RE: SSD-8924-The new Sydney Fish Markets Concept and Stage 1
SSD-8925-The new Sydney Fish Markets Stage 2

We write to object to both of the above development applications for the new Sydney Fish Markets (SFM) on the following grounds:

Shadow Analysis : 21 June (Winter Solstice) 3 PM

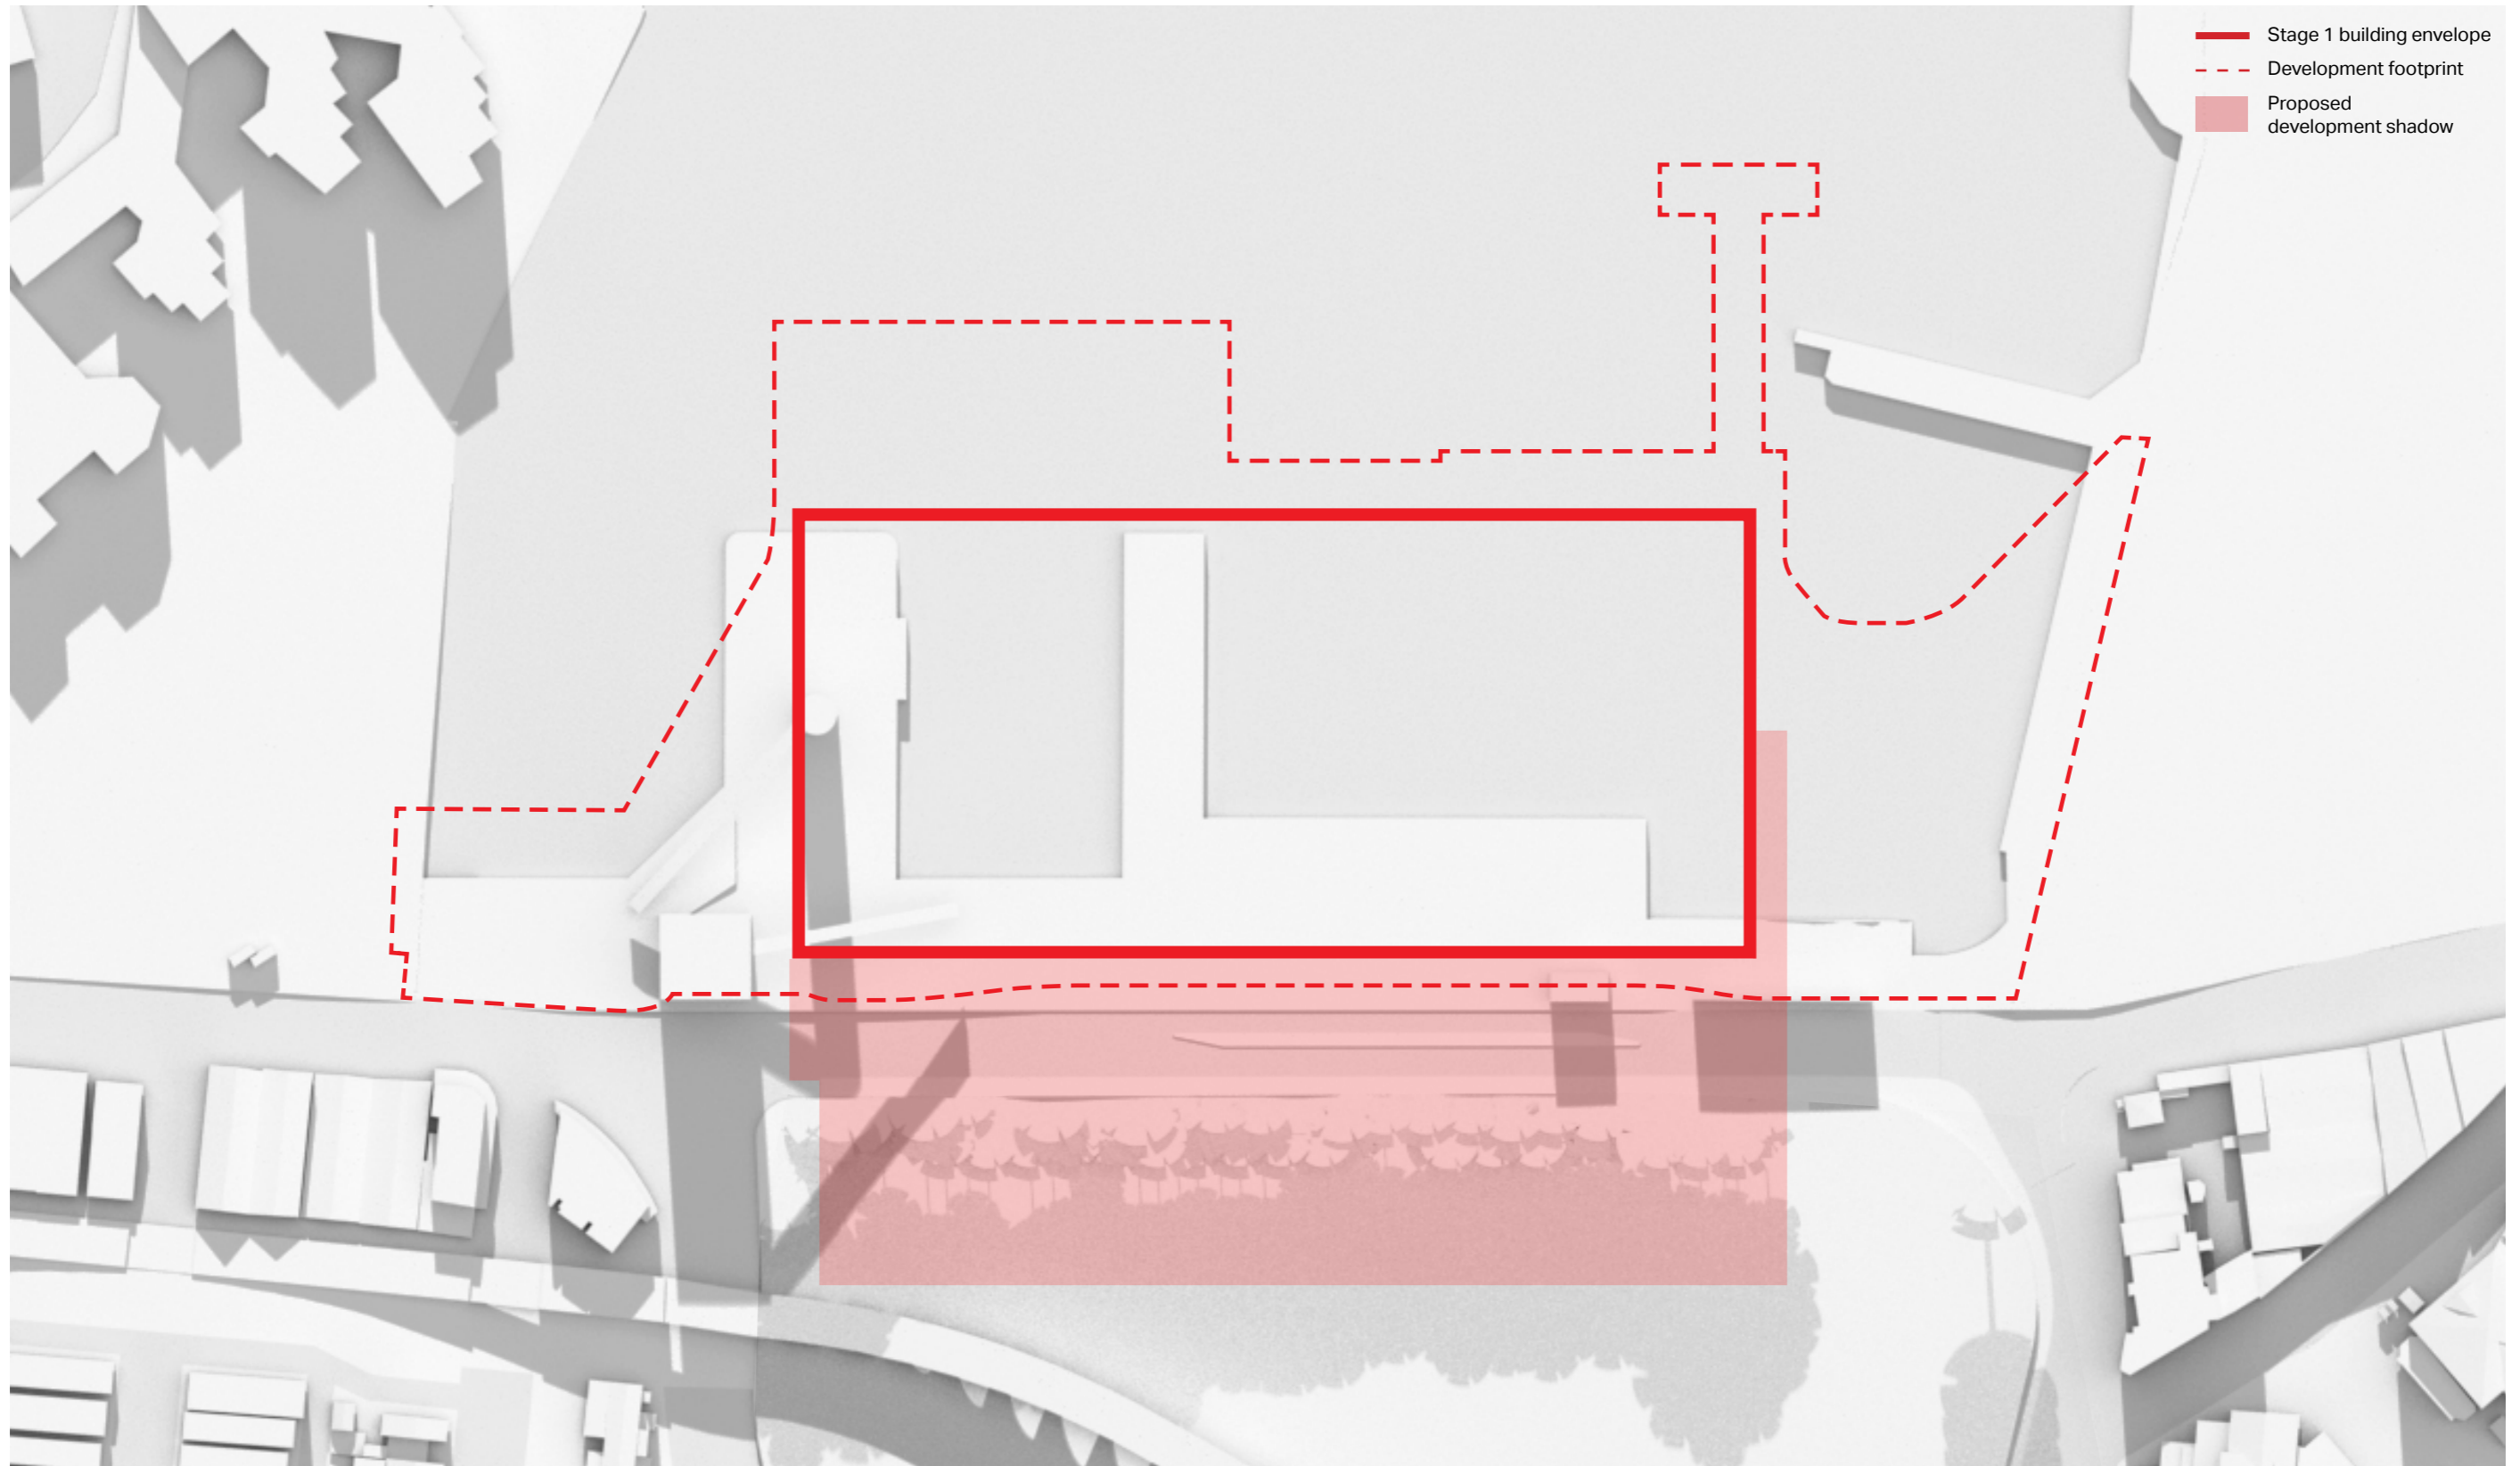
At 3pm on 21 June the proposed development will contribute to overshadowing around 30% of the park between Bridge Road and the railway viaduct. By 3.30pm this will increase to nearly 50% and by 4pm nearly 70%.

Low angle winter afternoon sunlight currently penetrates through and under the fig trees providing filtered sun light rather than the uniform overshadowing resulting from the proposed development.

The area of increased overshadowing contains a football pitch used extensively over the winter months for recreational sport. The additional overshadowing will impact on the players, spectators and the maintenance of the pitch.

Diagram - Height and scale of envelope

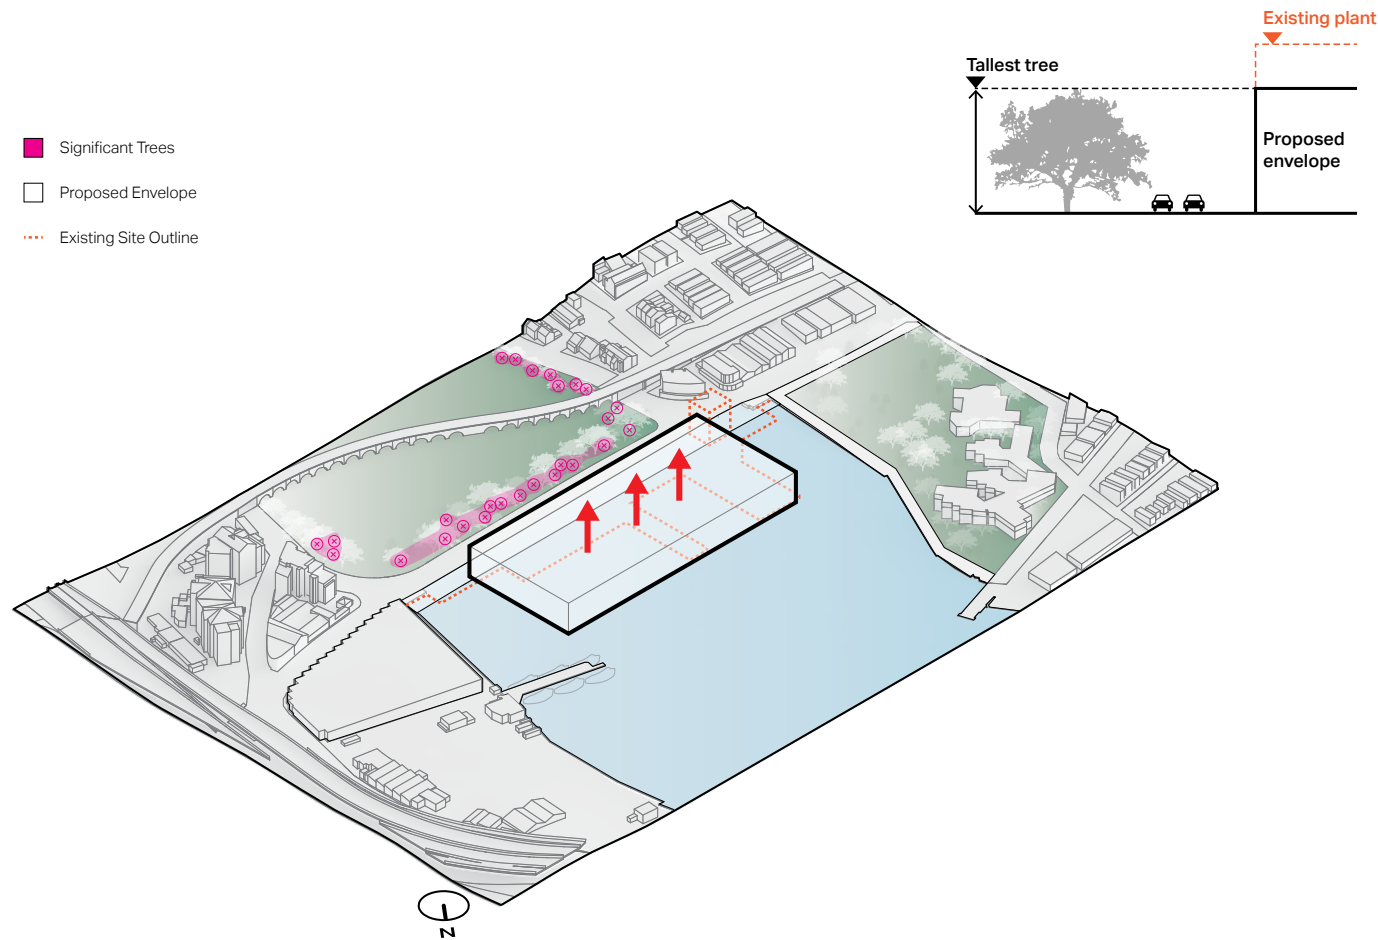
The EIS identifies the height of the fig trees along the edge of the park and the existing concrete batching plant as informing the height of the proposed development. The comparison is hardly valid as the proposed development has a footprint many times greater in area than the batching plant structures and the fig trees are a diaphanous, not a glass curtain wall, concrete and steel structure.

Diagram - Articulation of envelope bulk and scale

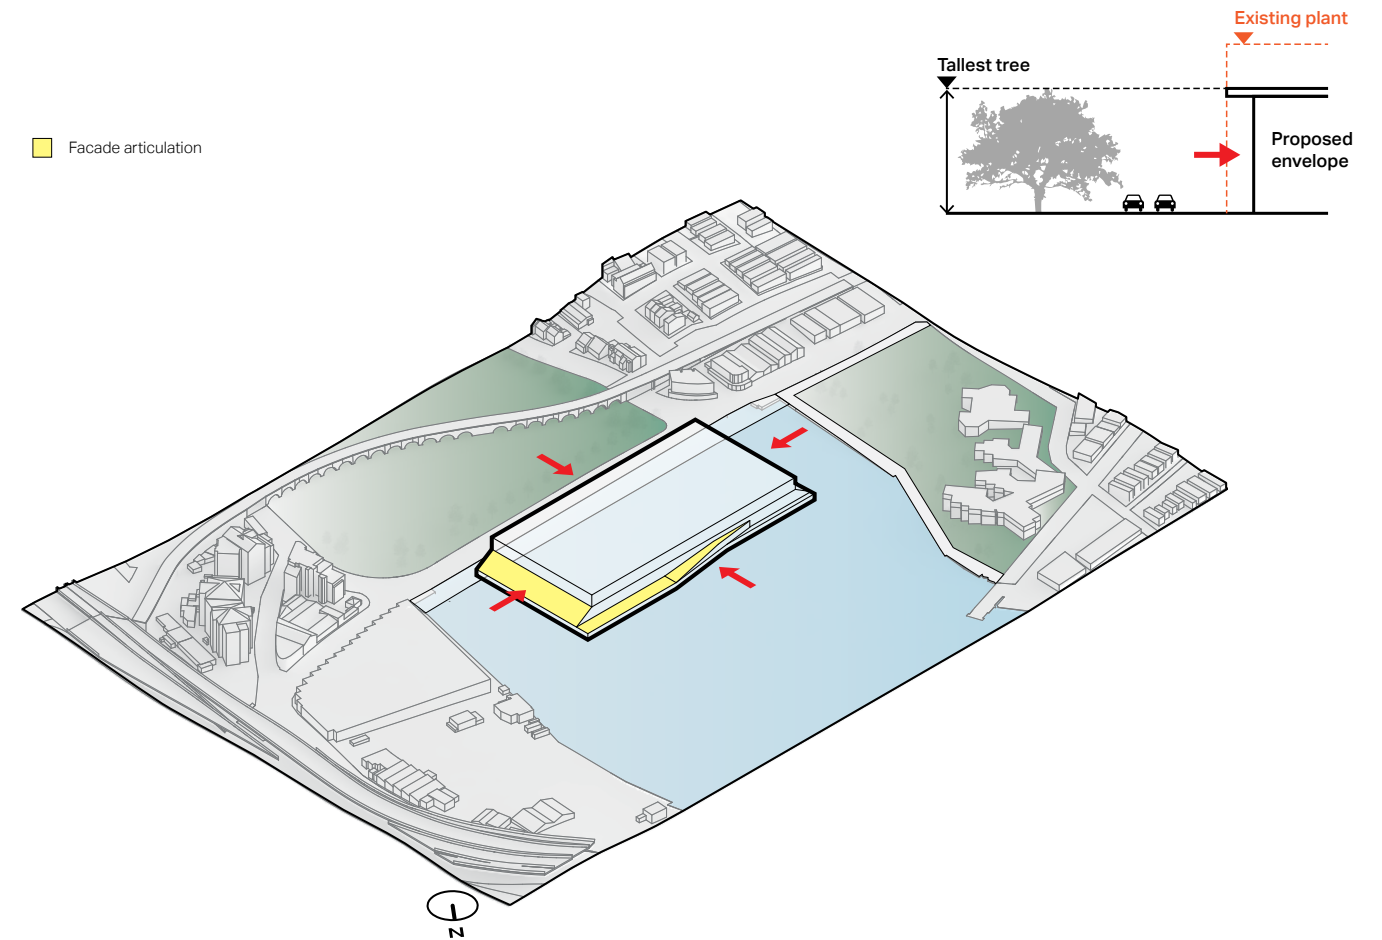
The EIS acknowledges that the proposal is larger than most other buildings in the area. The justification that the scale of the proposed development is reduced by the transparency and modulation of the facades is specious. Glass is not completely transparent, largely dependent on internal and external light conditions.

On southern elevations glass tends to reflect light rather than be transparent so there would be a lack of transparency along the Bridge Road frontage where there is a fairly consistent glass curtain wall façade around 16.5m or over 5 storeys high.

## Diagram : Promenade Zones

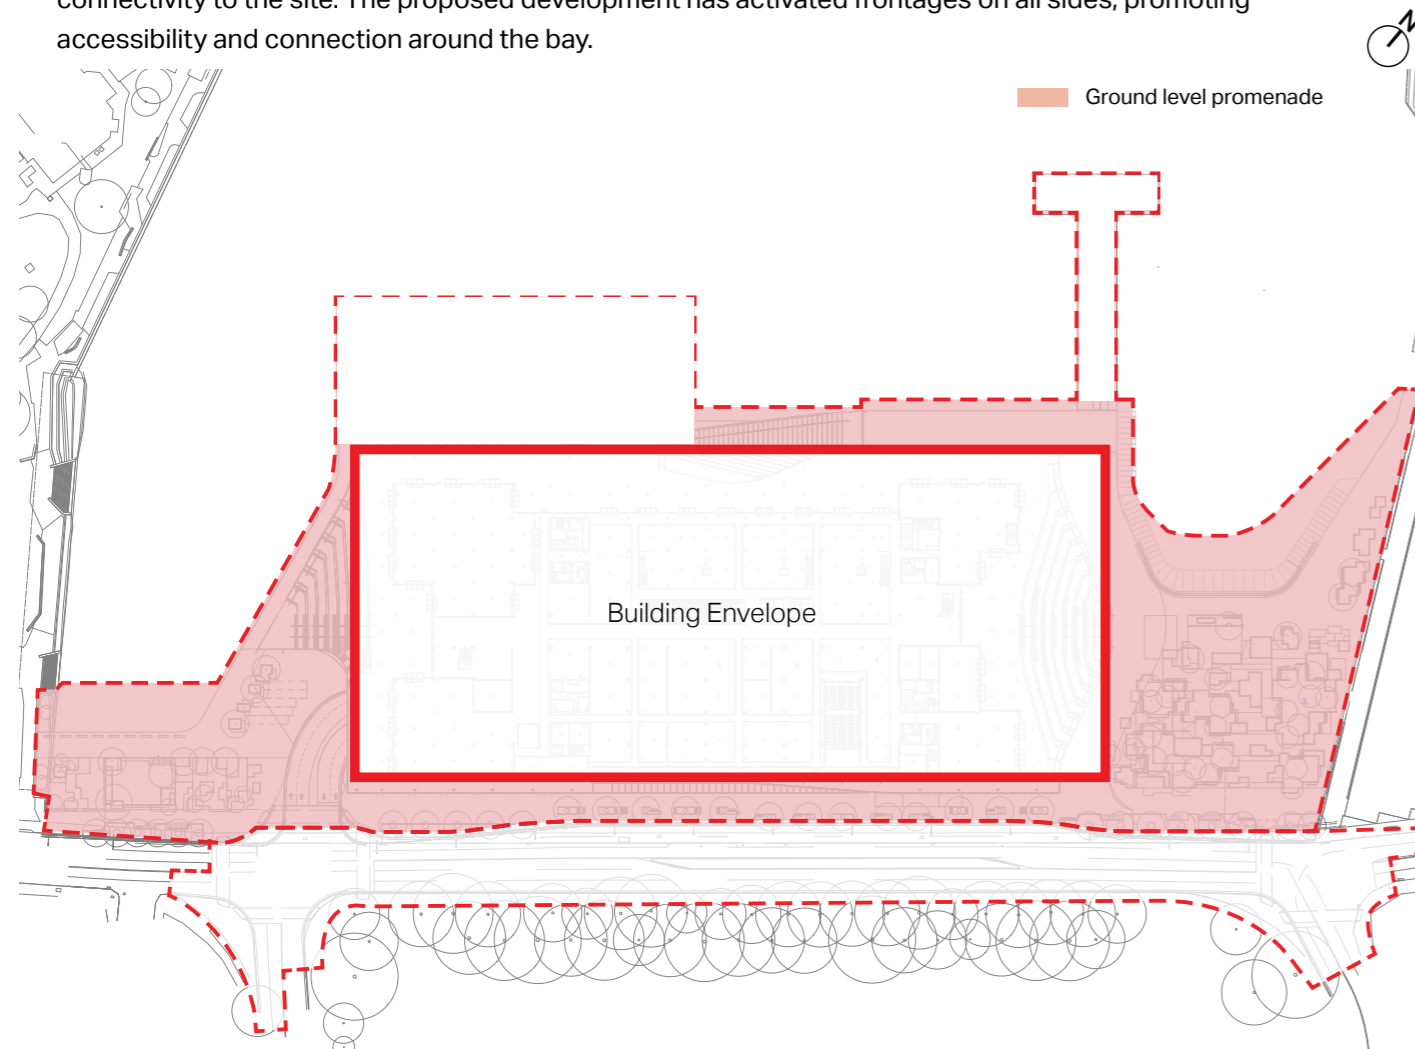
Pedestrians wishing to continue along the waters edge can only do so via a series of stepped walkways leading onto an elevated terrace lined with retail outlets. There is no choice to this path other than along Bridge Road.

Pedestrians are forced into a retail area particularly at its northwestern end. Here access is pinched into a terrace area some 10m wide which appears to be largely devoted to outdoor seating serving the adjacent retail areas.

The promenade area would effectively operate similar to a shopping centre food court, not a harbor foreshore public space.

**Diagram : Park to Water Views**

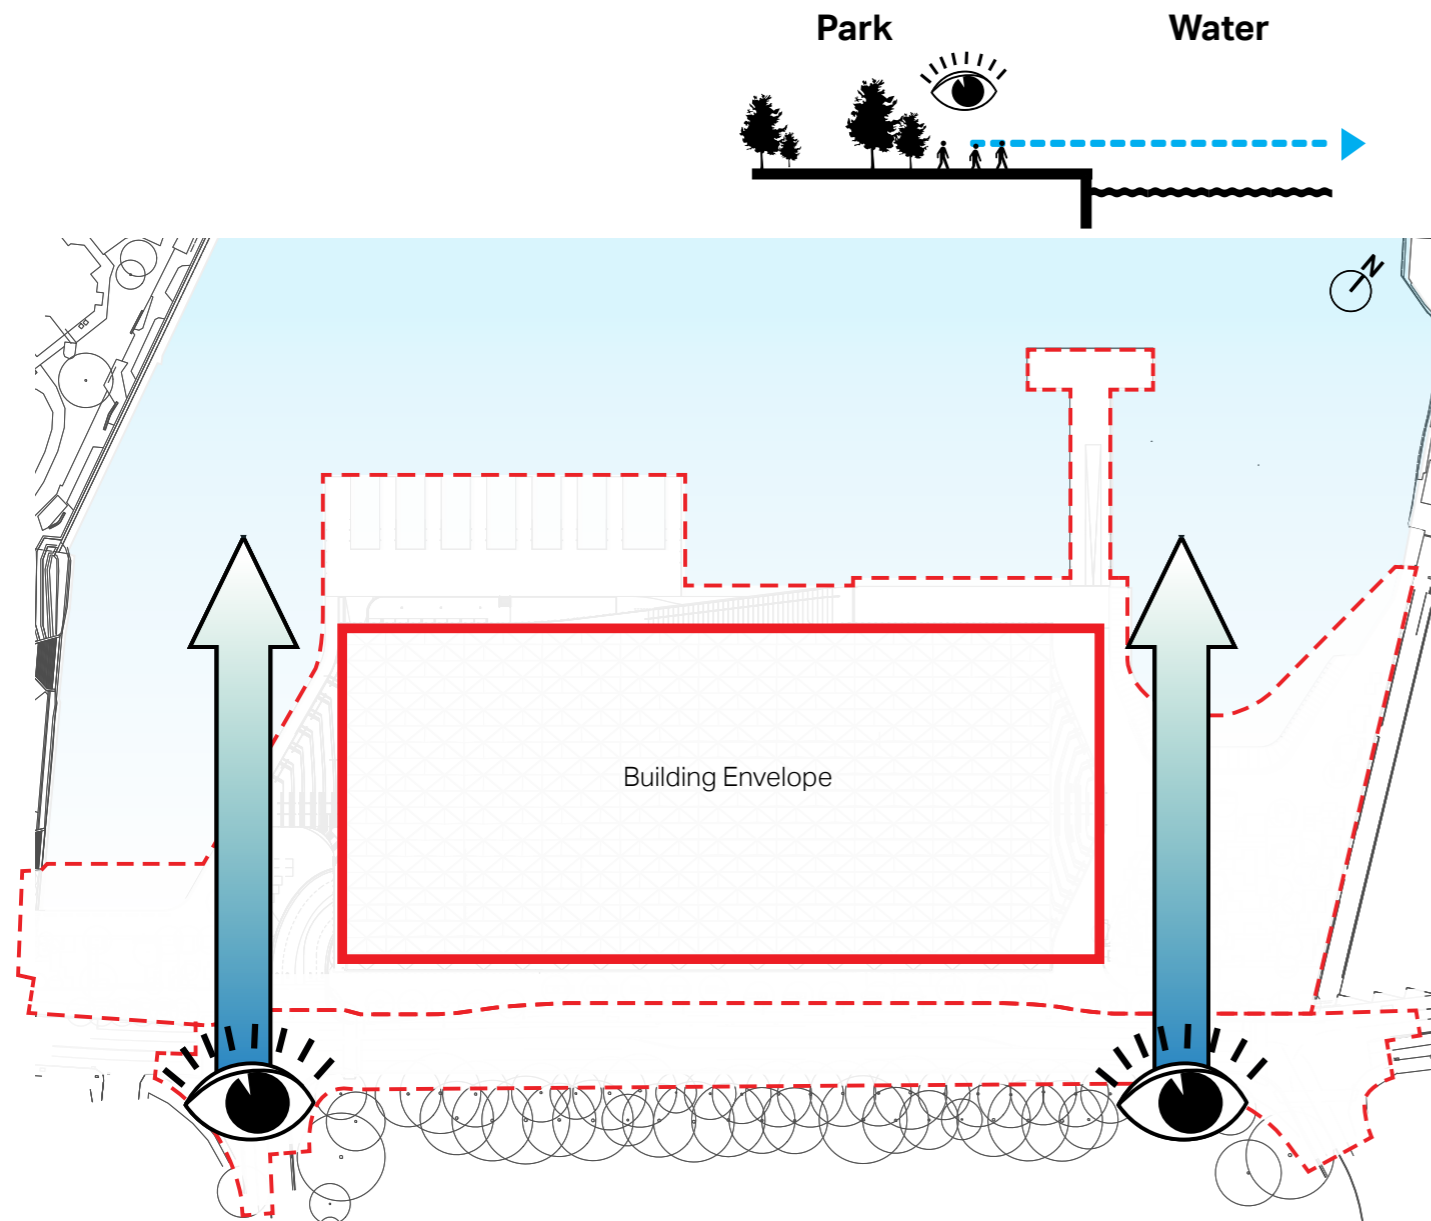
Vistas from the bay to the avenue of fig trees along Bridge Road would be screened behind a 21-23m high view barrier running the entire length of the park, as will any potential visual connection from the park to the harbour.

The EIS claims that the proposal will open up new "view corridors" for the park at the western and eastern ends. Arguably these are existing view corridors and relate more to the Wentworth Park Road and Wattle Street intersections with Bridge Road rather than the park itself as the EIS views and vistas analysis clearly illustrates. The proposed development places greater significance on providing view corridors for traffic intersections over those from the park.
